Subject: Objection to planning Application Number 2019/91141

I would like to raise an objection in relation to the proposed single dwelling on land adjacent to 320, New Hey Road, Oakes, Huddersfield, HD3 4GQ; 2019/60/91141/W.

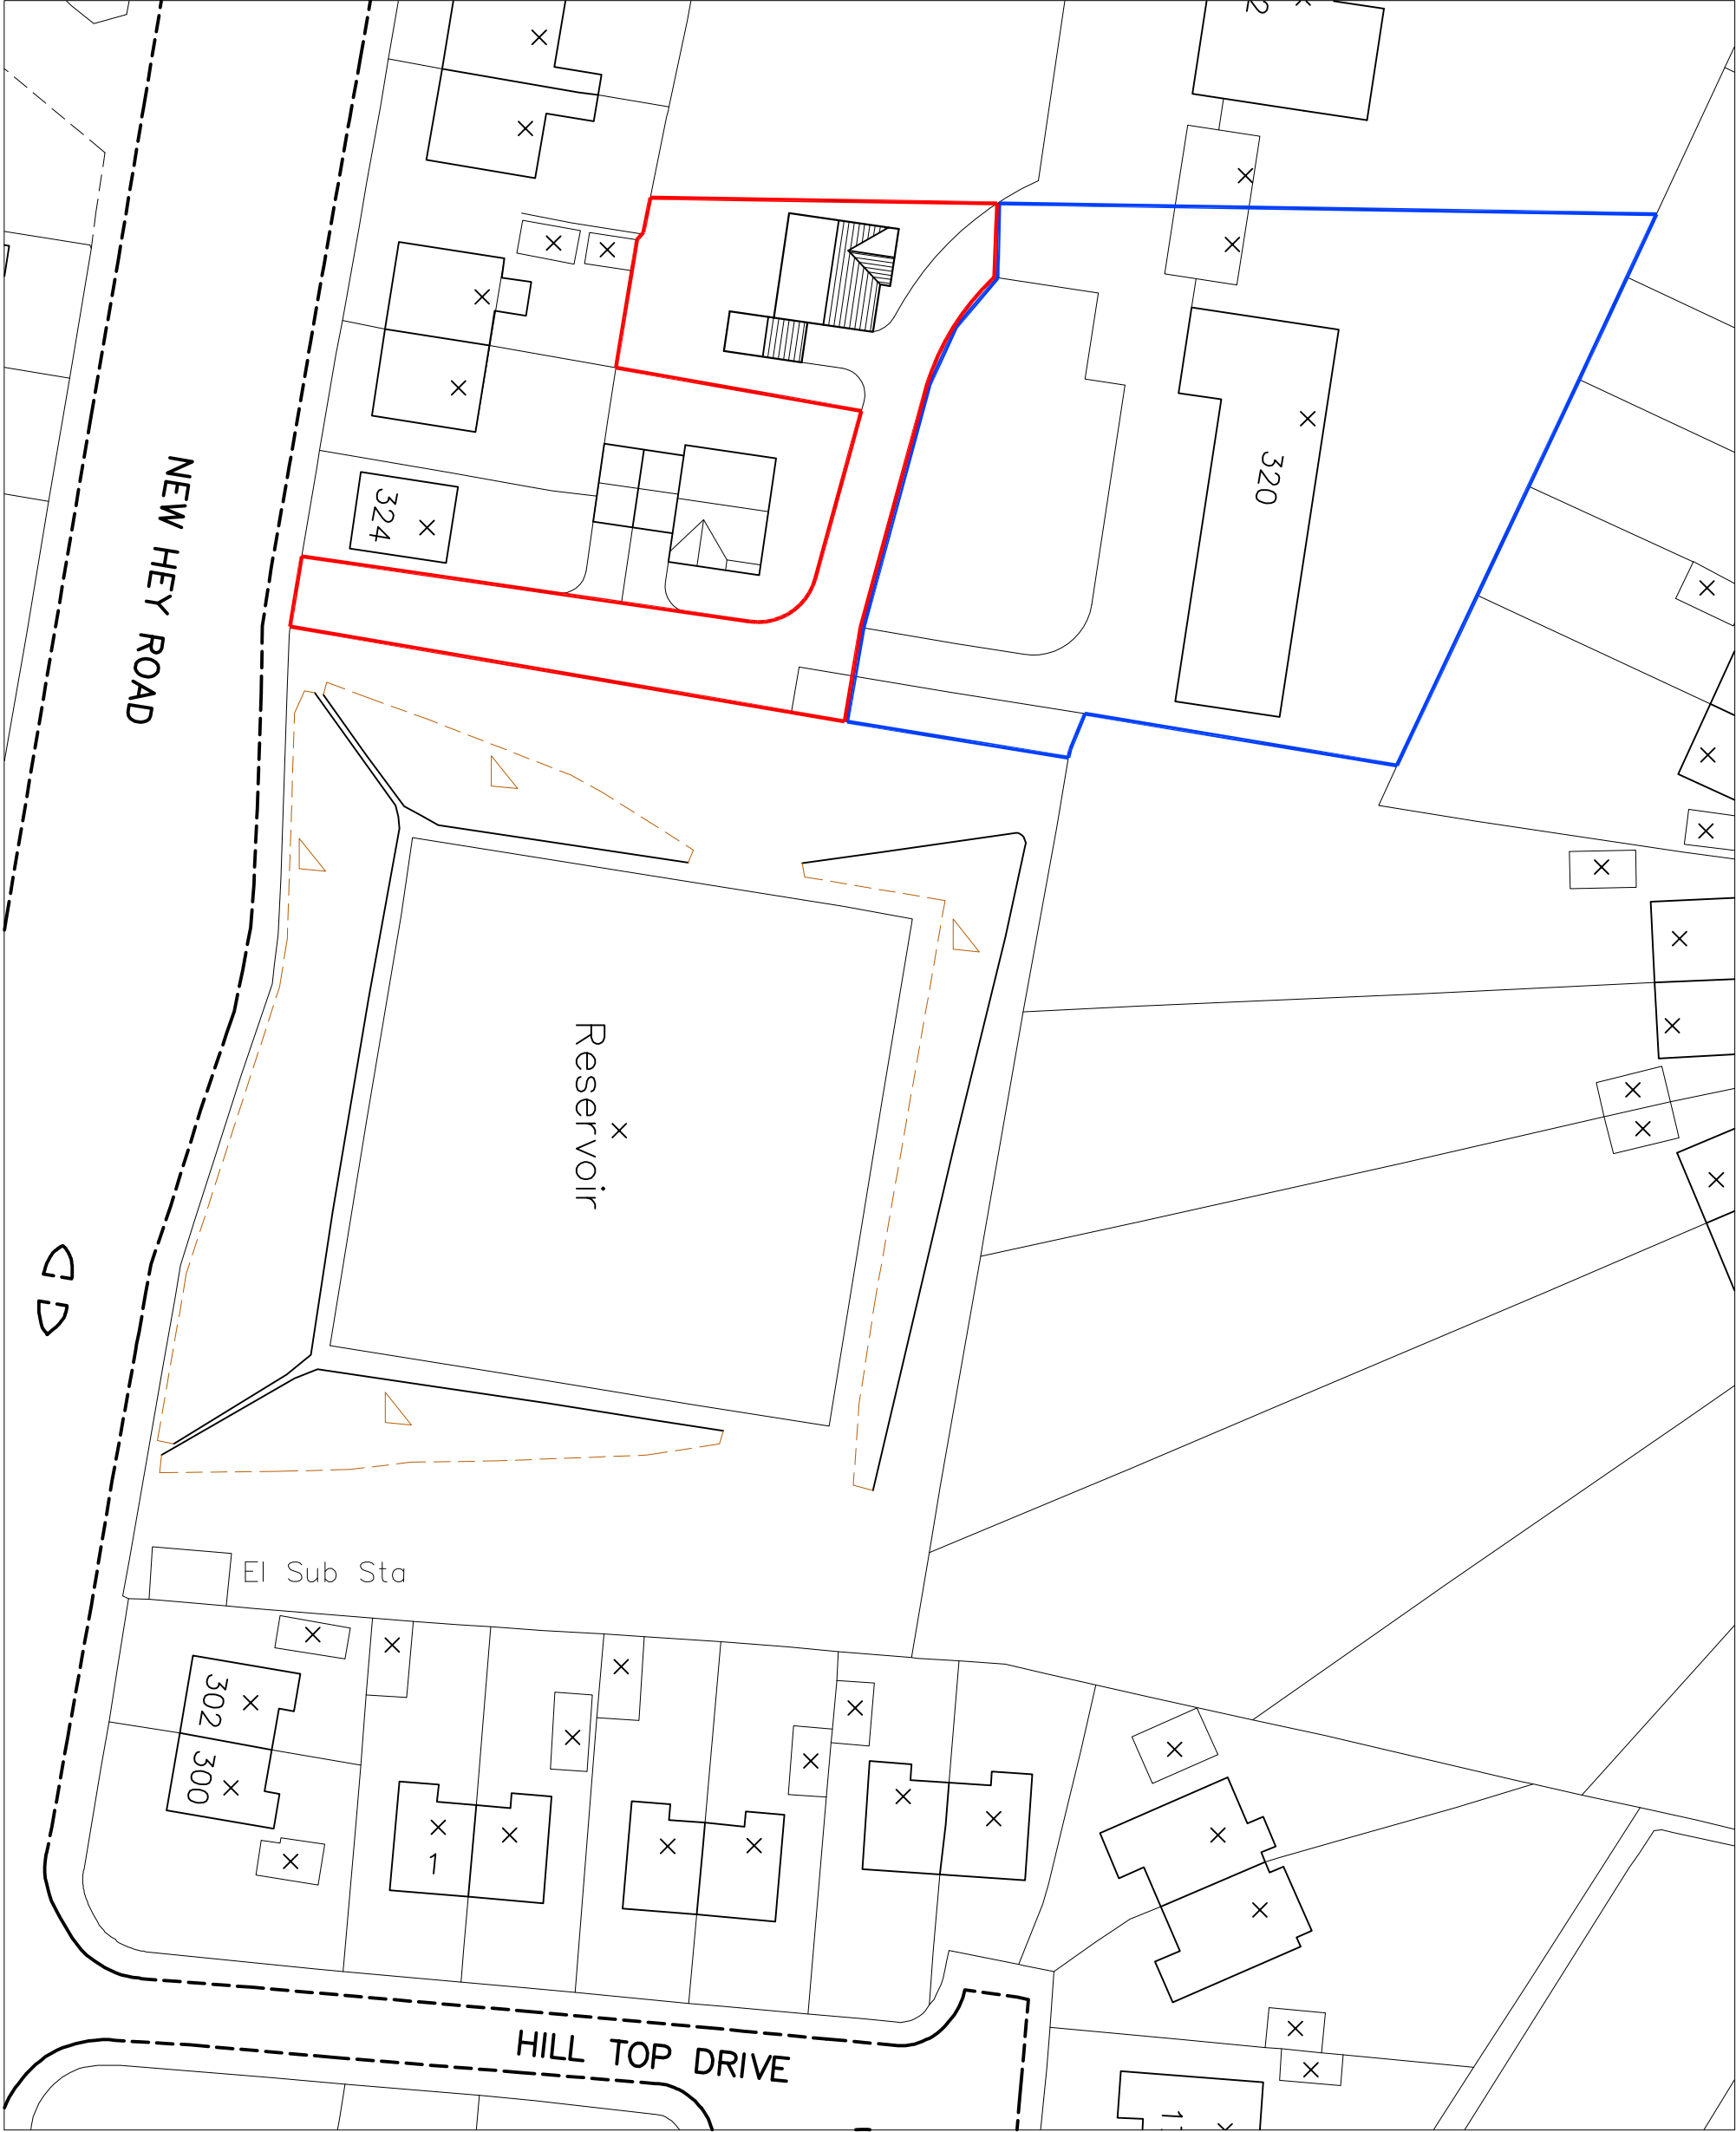
Worryingly the ordinance survey is out of date some revisions are dated 2008, with no license reference. I assume this plan has been reused from the previous applications and is supplied without the license reference being shown breaching the requirements of Kirklees council and copyright laws.

STREET ELEVATION FROM
NEW HEY ROAD

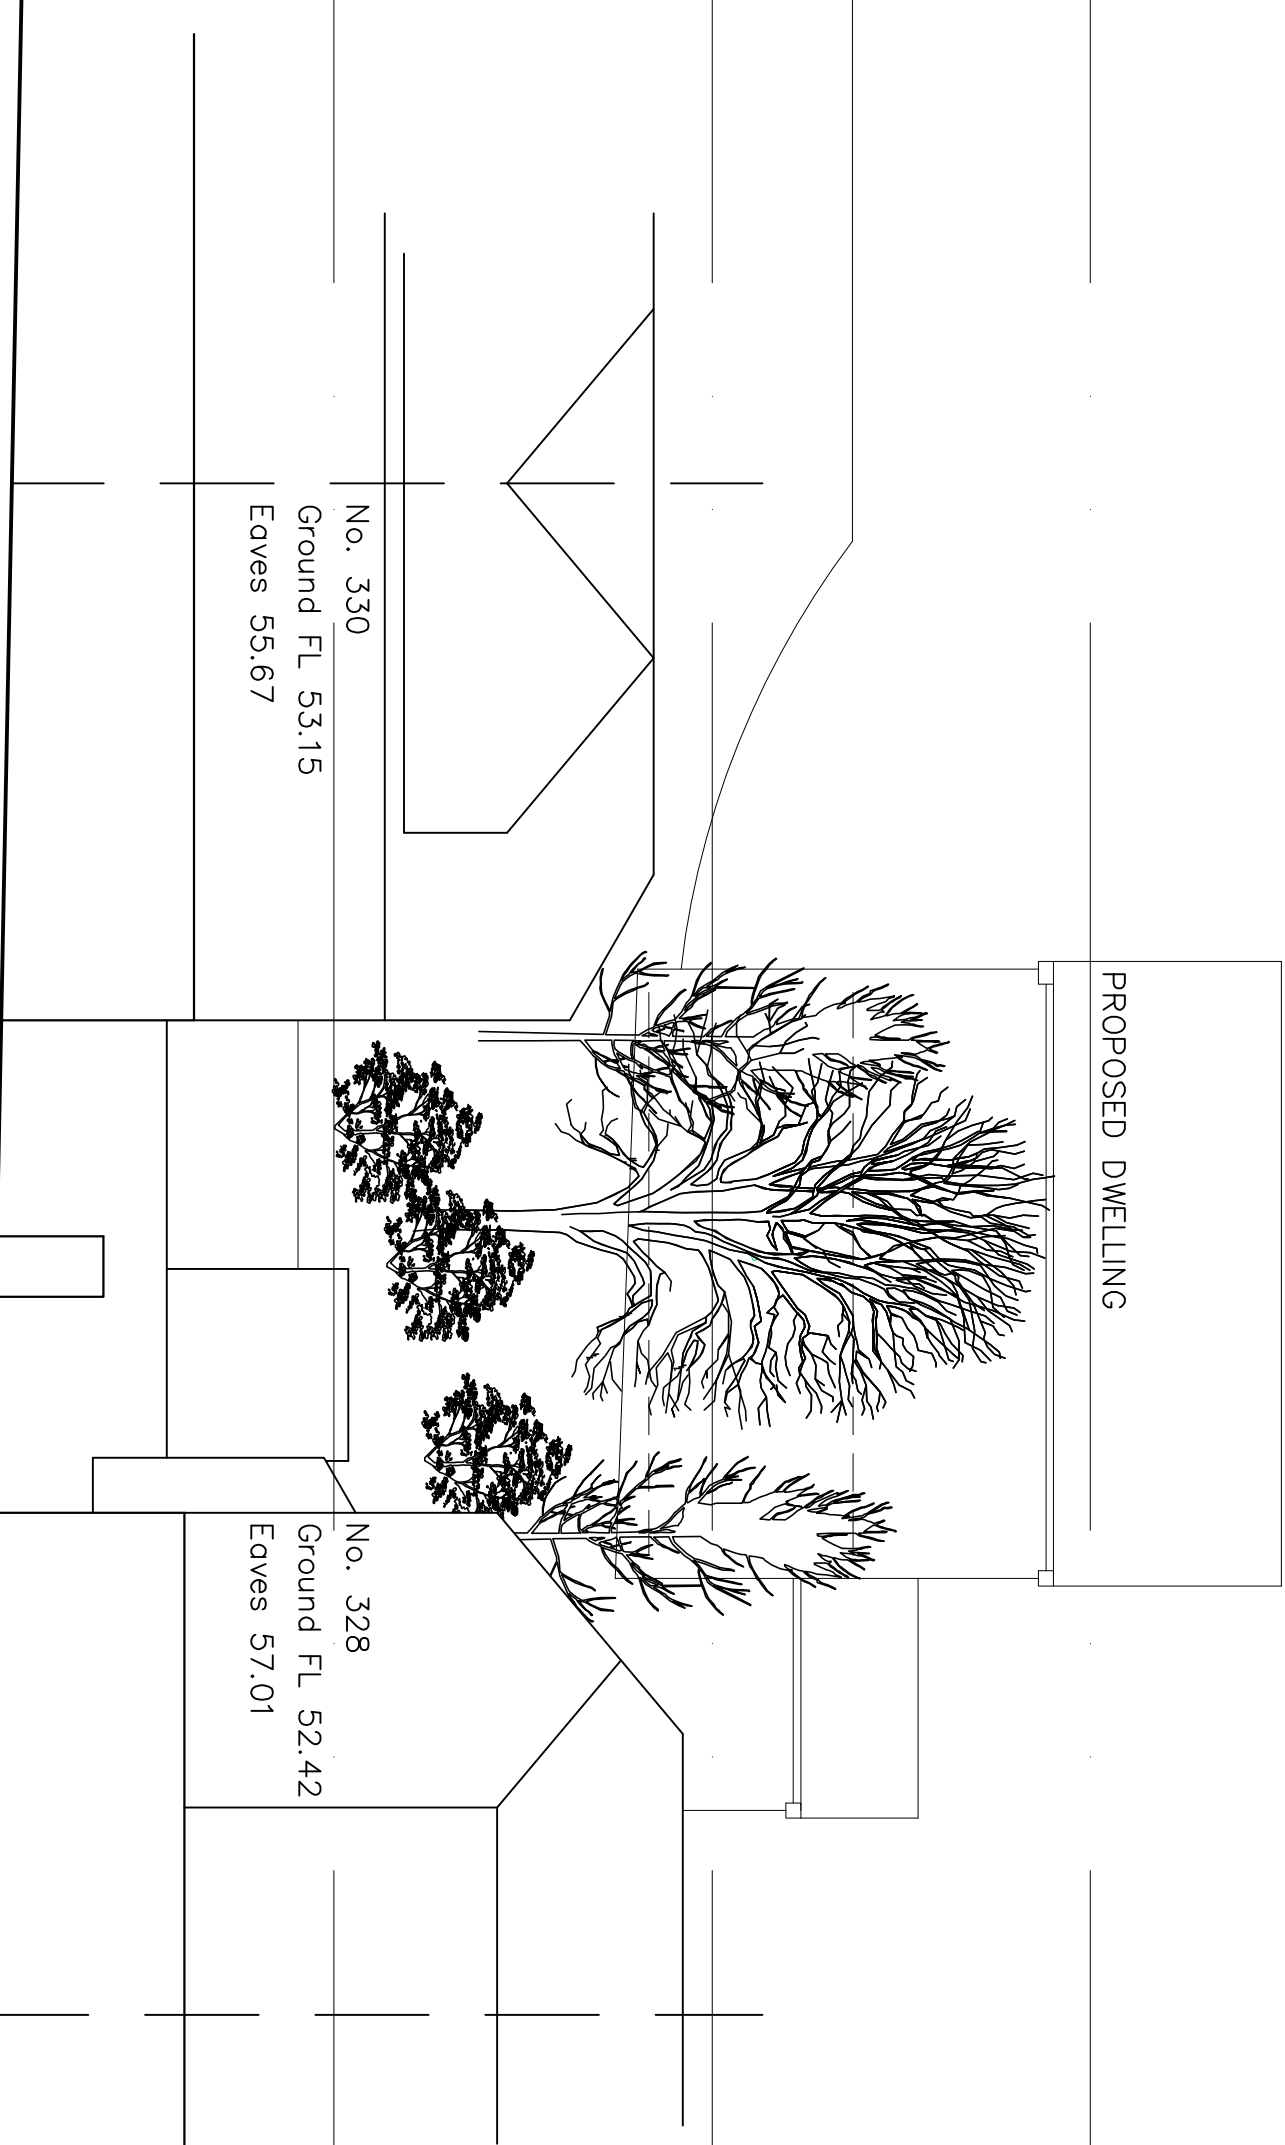
I note the dimensions on the proposed scale drawing and have cross referenced this with the previous application street scene drawing. While I note there are no windows presented at this time, one would assume there will be habitable rooms to the first floor. If any of these were to have a window facing South or East a total and utter loss of any and all privacy to the adjacent properties would occur, even considering the surviving trees and potential boundary fences where present. Due to the proximity and steep topographical position the dwelling would present as an overbearing dwelling with significant impact on the remaining private amenity space of immediate properties to the East and South.
